Our Case Number: ABP-313509-22

Re: BusConnects Belfield/Blackrock to City Centre Core Bus Corridor Scheme
Co. Dublin

Re: BusConnects Belfield/Blackrock to City Centre Core Bus Corridor Scheme

Programme Title: <b>BUSCONNECTS DUBLIN CORE BUS CORRIDORS INFRASTRUCTURE WORKS</b>			
Drawing Title: BELFIELD / BLACKROCK TO CITY CENTRE CORE BUS CORRIDOR SCHEME GENERAL ARRANGEMENT			
Drawing File Name: BCIDC-ARP-GEO_GA-1415_XX_00-DR-CR-0014	Sheet Number: 14 of 24	Status: A	Rev: M01

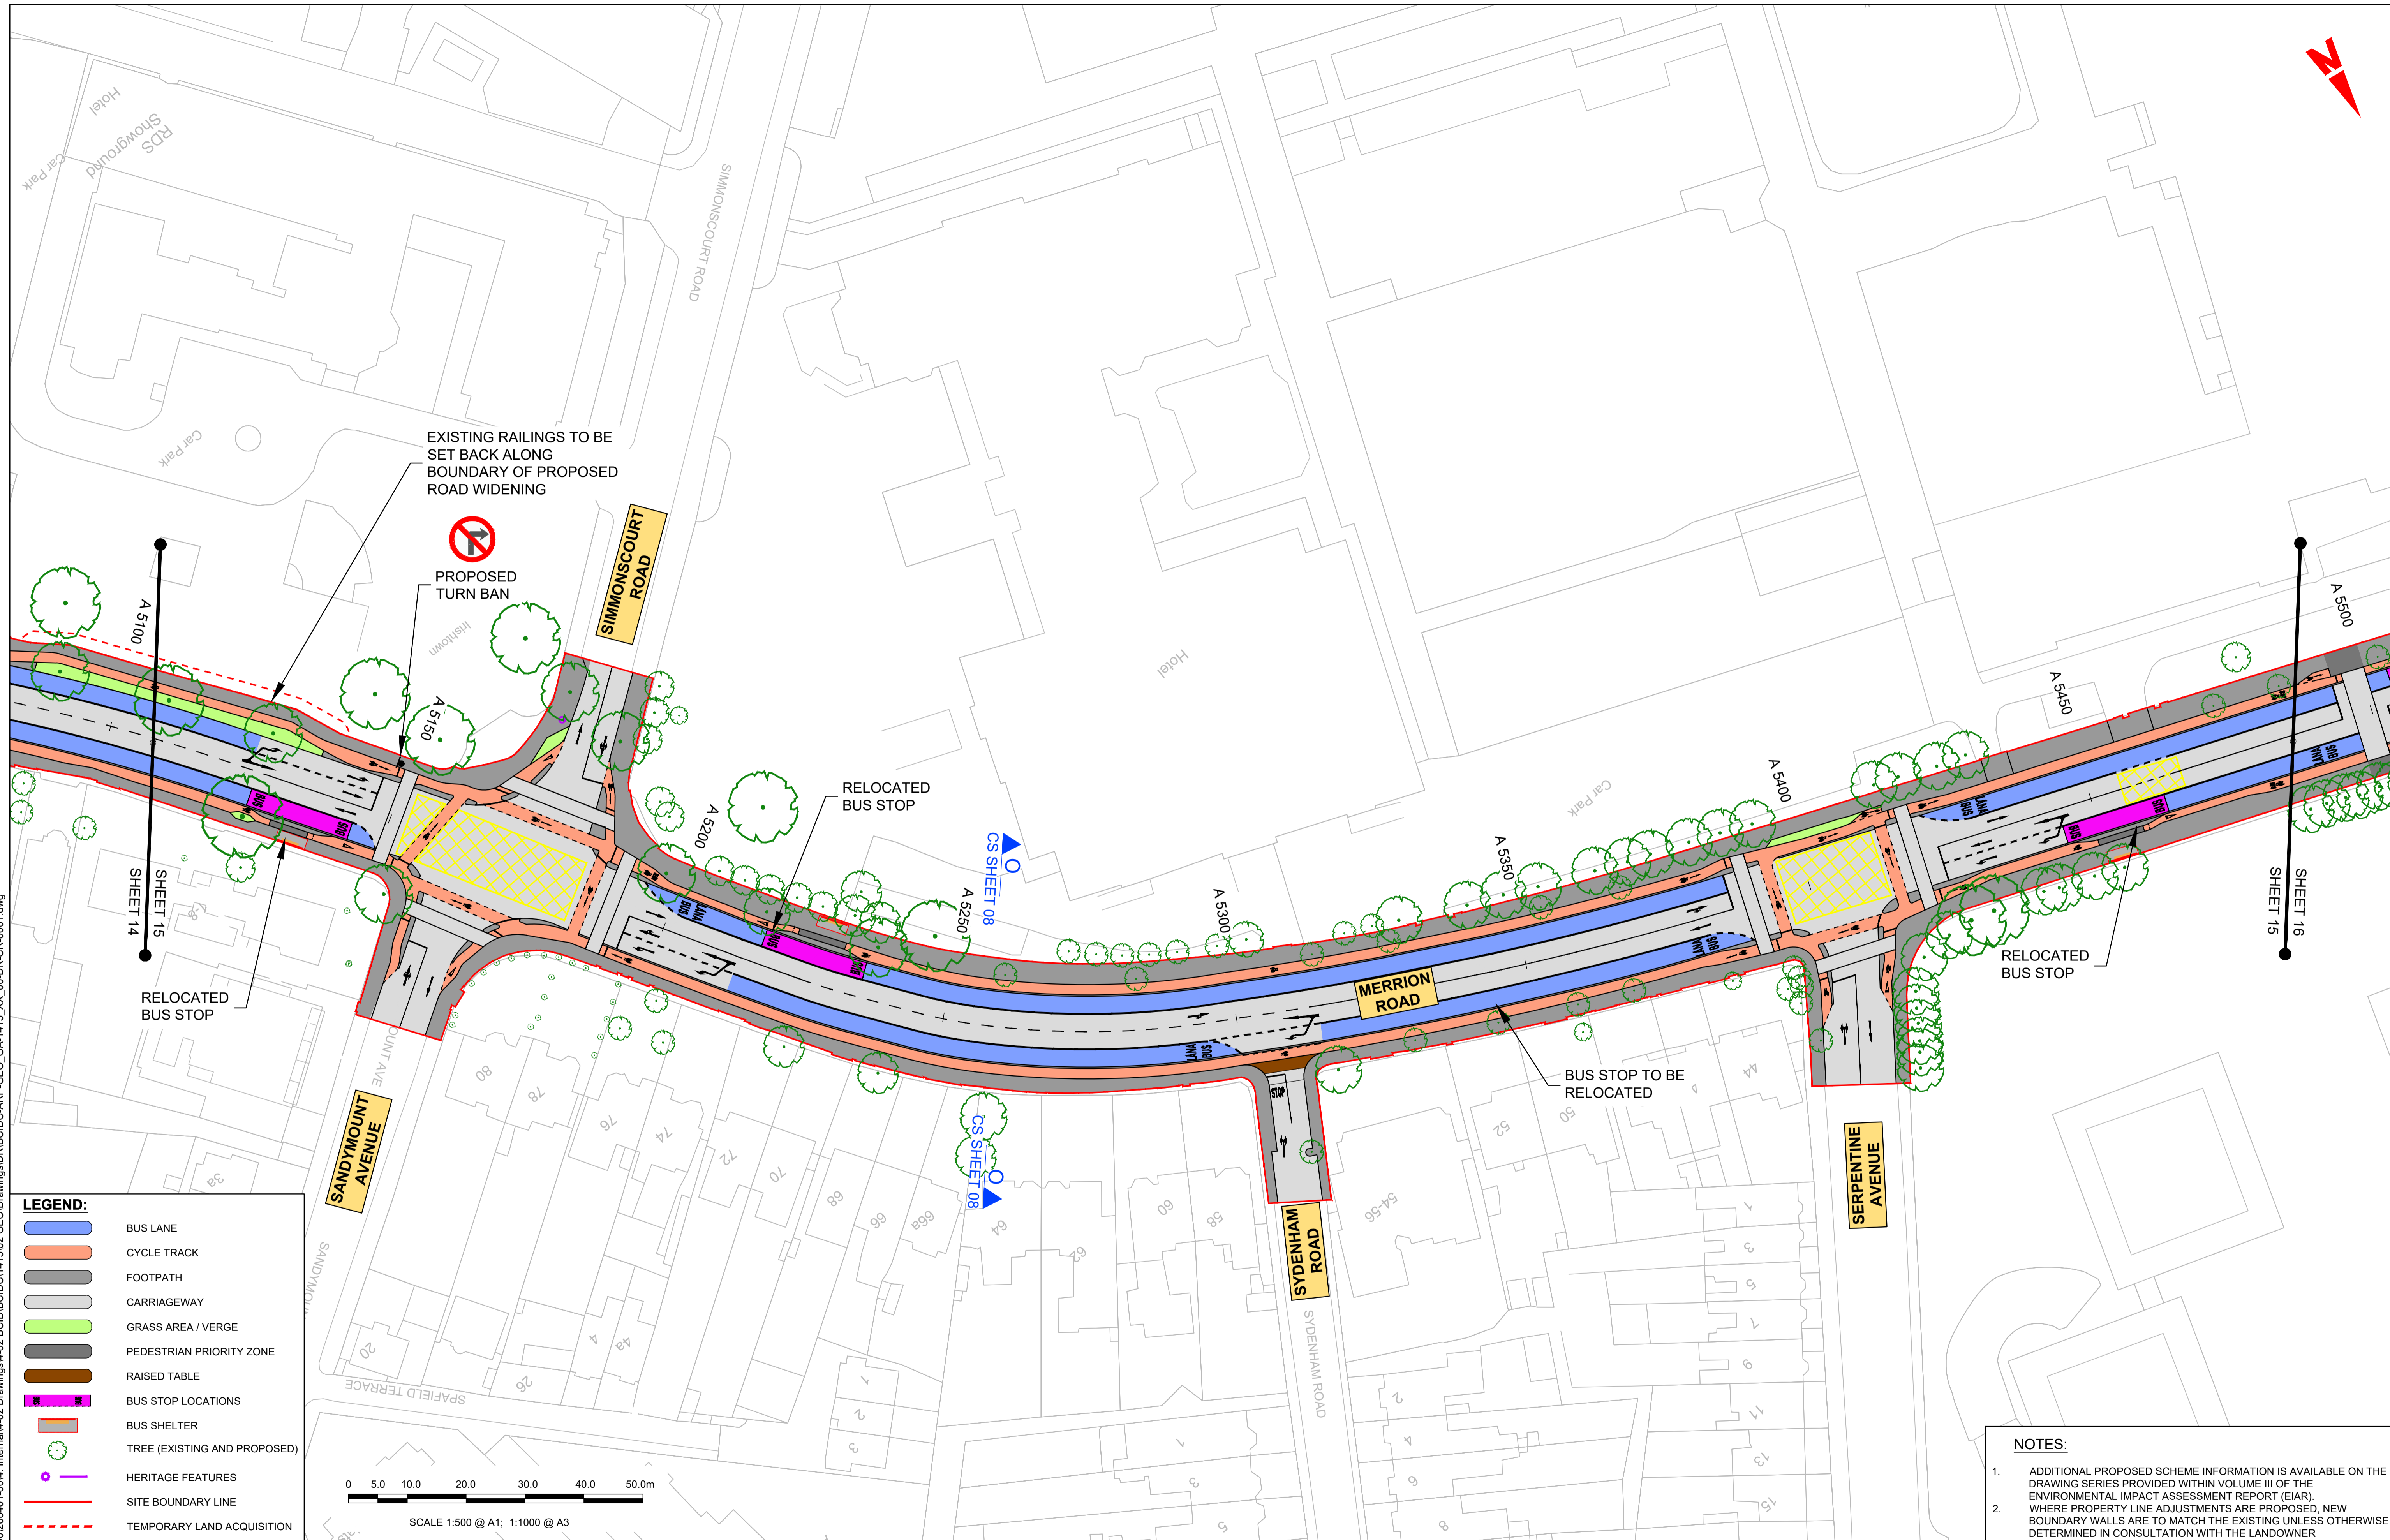
EIAR vol 2 CBC1415 Ch 4 proposed scheme page 4 '*At the access junction to SVUH from Merrion Road, the left-turn lane into SVUH ... been removed in order to improve cyclist safety and reduce the necessary land acquisition; but equally the general arrangements drawings page 14 has a left turn into hospital. Which proposal is correct??*
